# PROPOSED CHANGES APPLICATION REPORT

## Drax Bioenergy with Carbon Capture and Storage

**Document Reference Number: 8.5.1**

**Applicant: Drax Power Limited**

DRAWING NUMBER
 EN010120-PA-LP-8.5.3.9-Sheet2

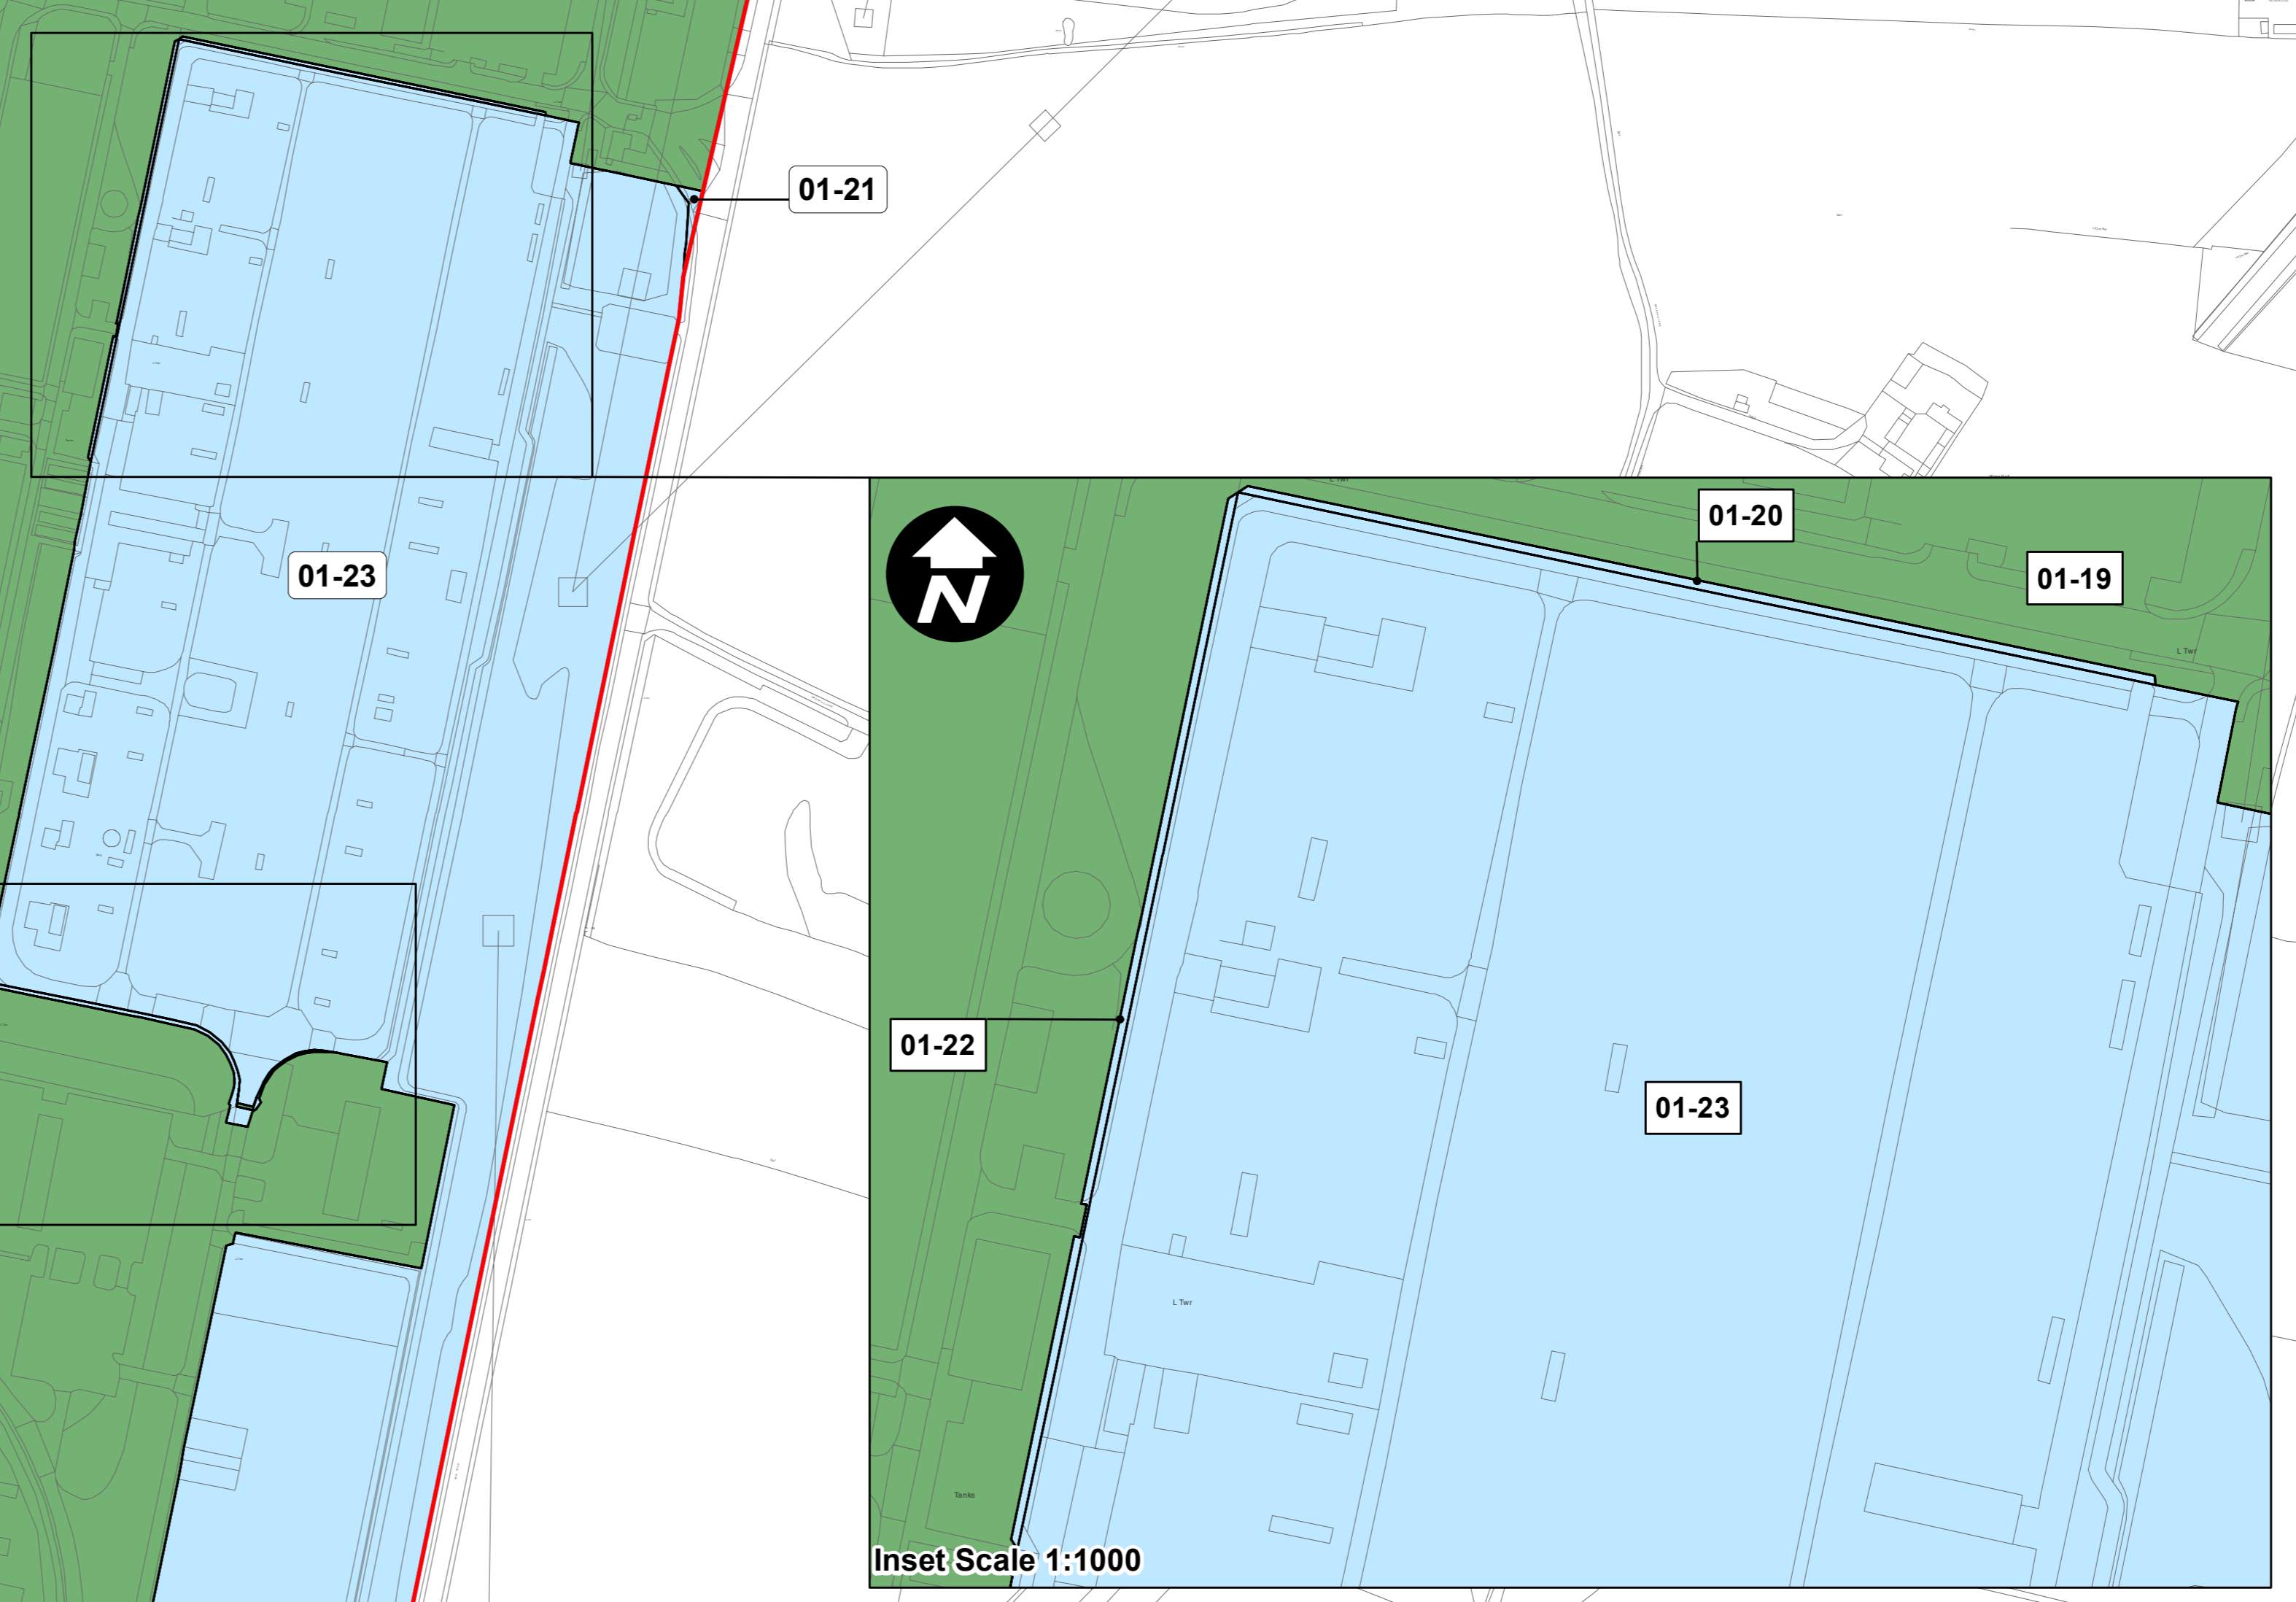
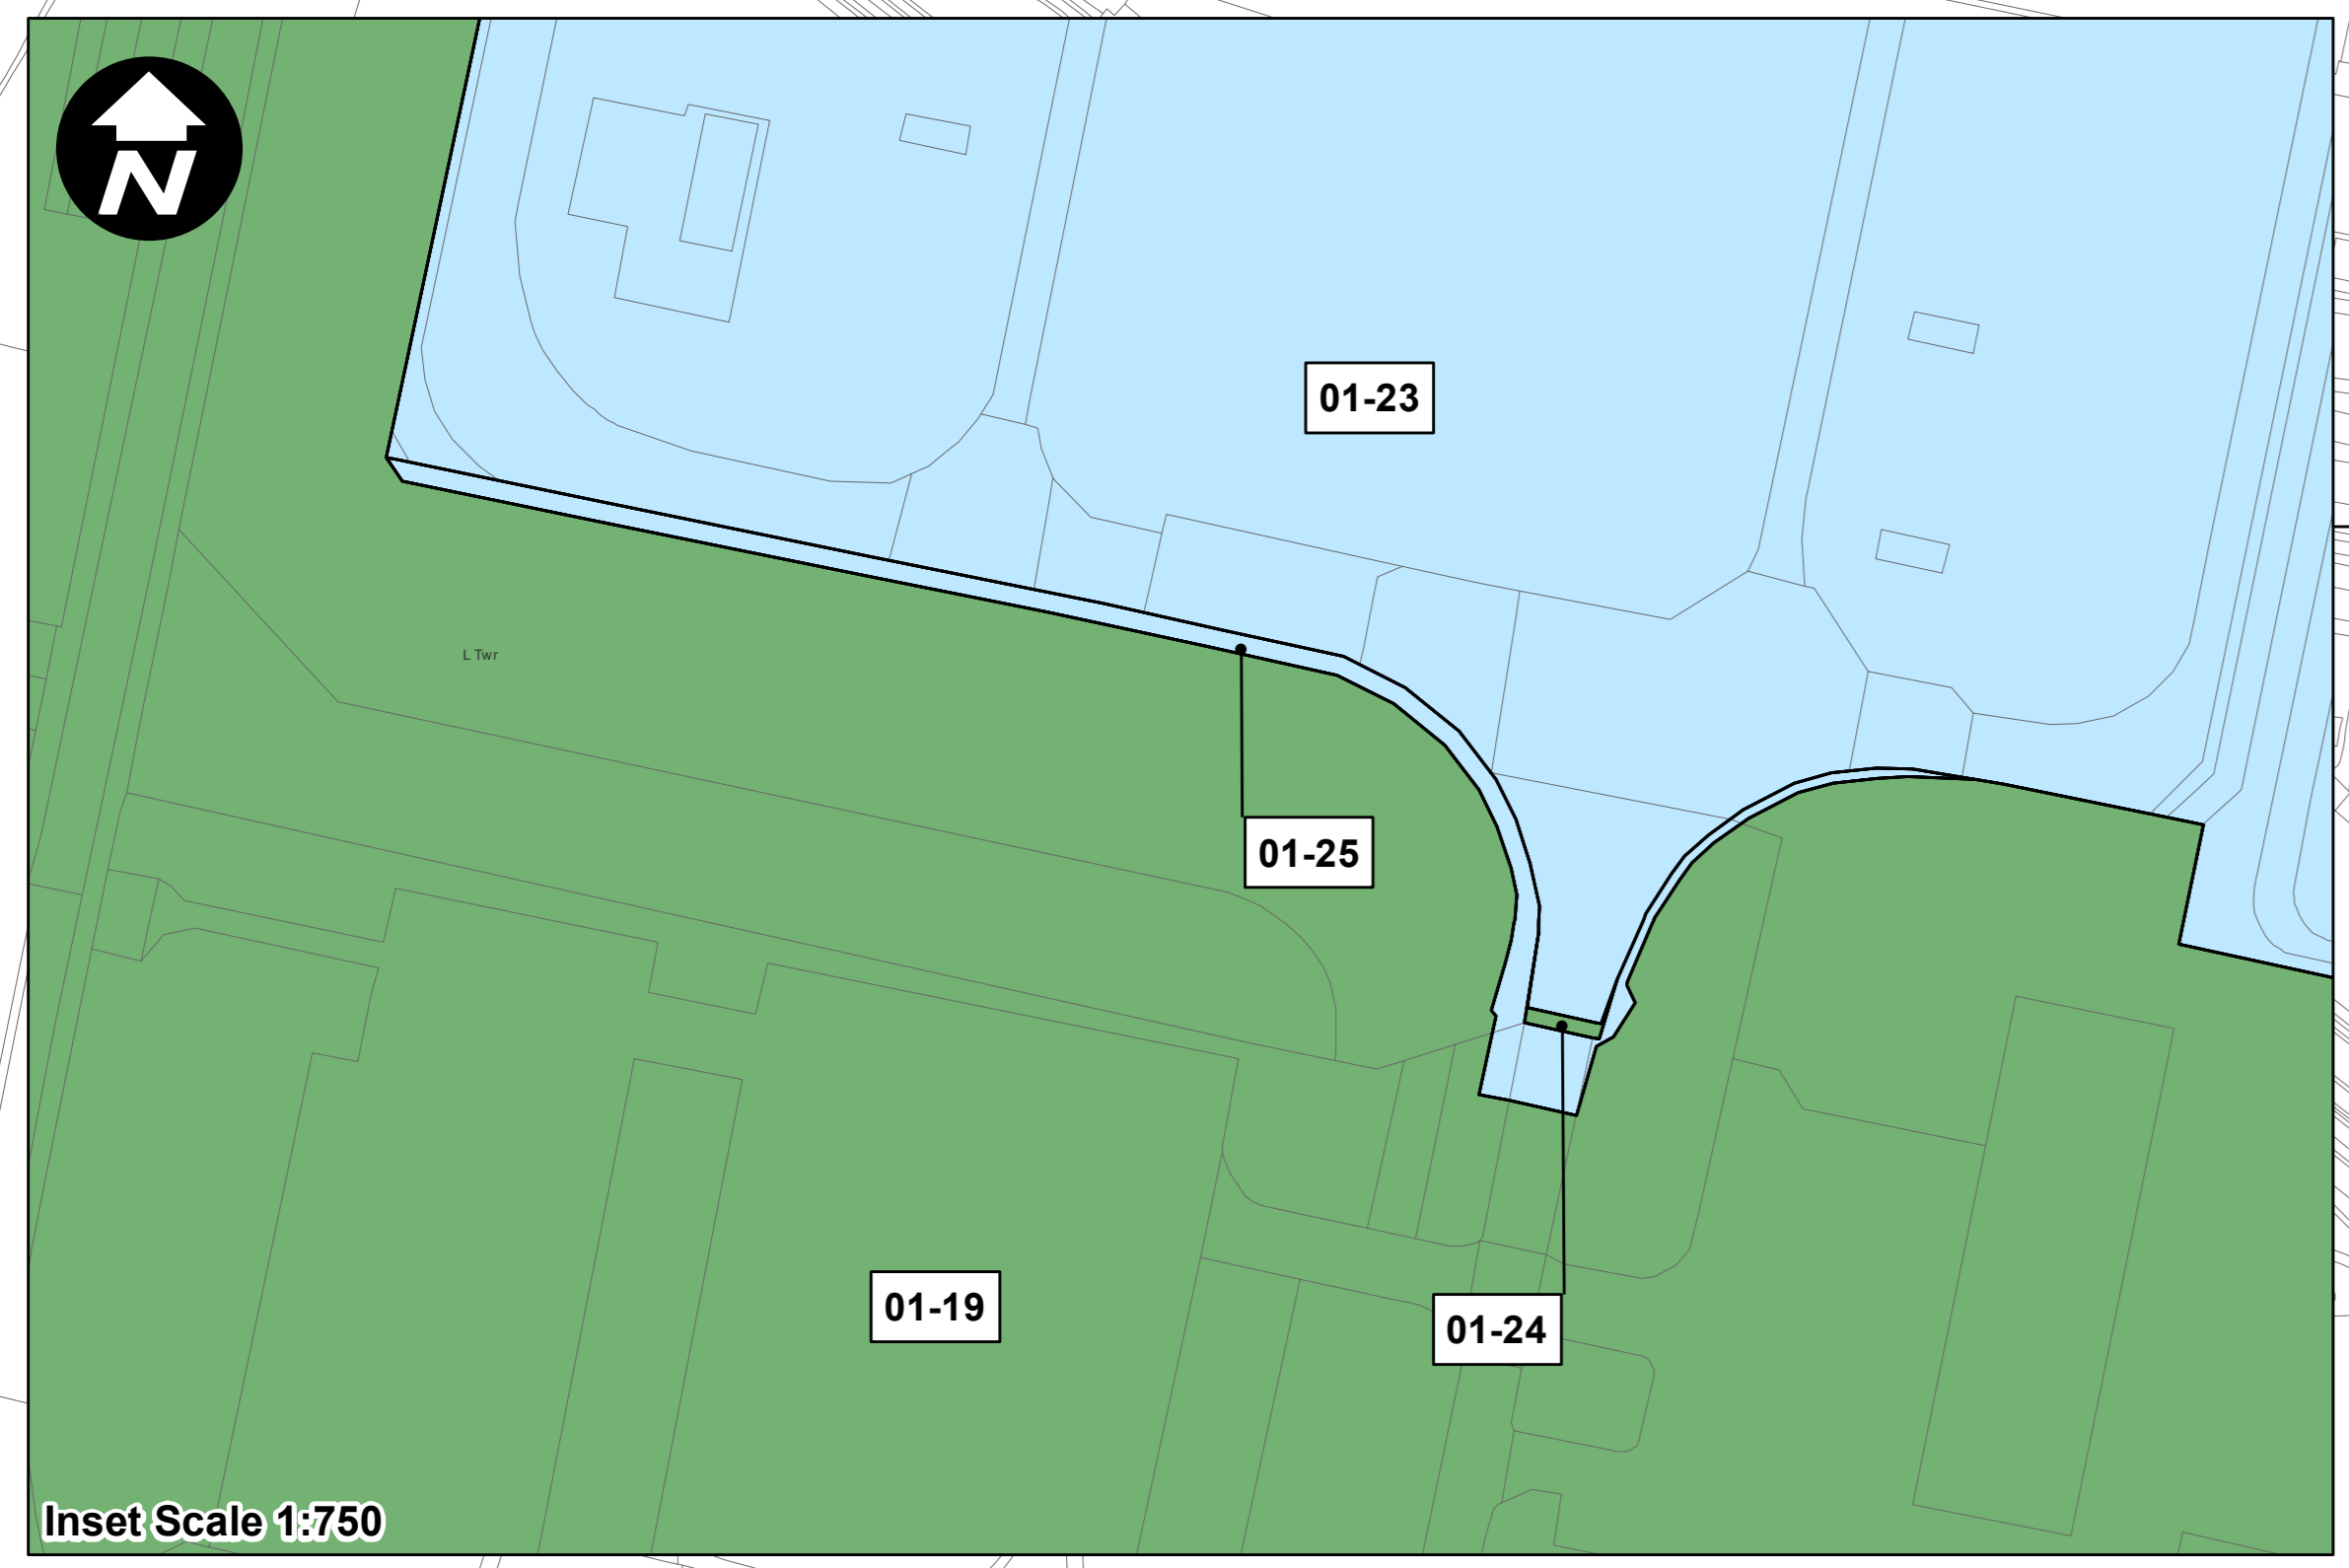
- b. Proposed Change 02 ('PC-02'): Relocation of existing overhead lines in respect of two electrical lines (11kv overhead line crossing the A645 once, owned by Northern Powergrid ('OHL1'), and 11kv overhead line crossing Rawcliffe Road once, owned by Northern Powergrid ('OHL2')) and the Telecommunications line crossing Rawcliffe Road twice, owned by Openreach ('TCL1'), which cross the access route to the Site at A614 (Rawcliffe Road) and the A645, to allow for the delivery of Abnormal Indivisible Loads (AILs) to the Site. This Proposed Change involves land that is outside of the current Order Limits and is not in the ownership of the Applicant.

- 2.1.18. Following submission of the Application, further technical work and ongoing discussions with the owner of the affected Lines (Northern Powergrid and BT Openreach), has identified that the following works may be needed to resolve the conflict between the AIL movements and the Lines:

- a. Undergrounding is the preferred approach, but that as a consequence, a slight realignment of the retained Lines and restringing works may also be necessary;

- b. Undergrounding needs to take place for the section of the electrical lines which is supported by telegraph poles, i.e. from 'pole to pole', rather than just for the section of line which sits over the highway. This requires land outside of the highway boundary;
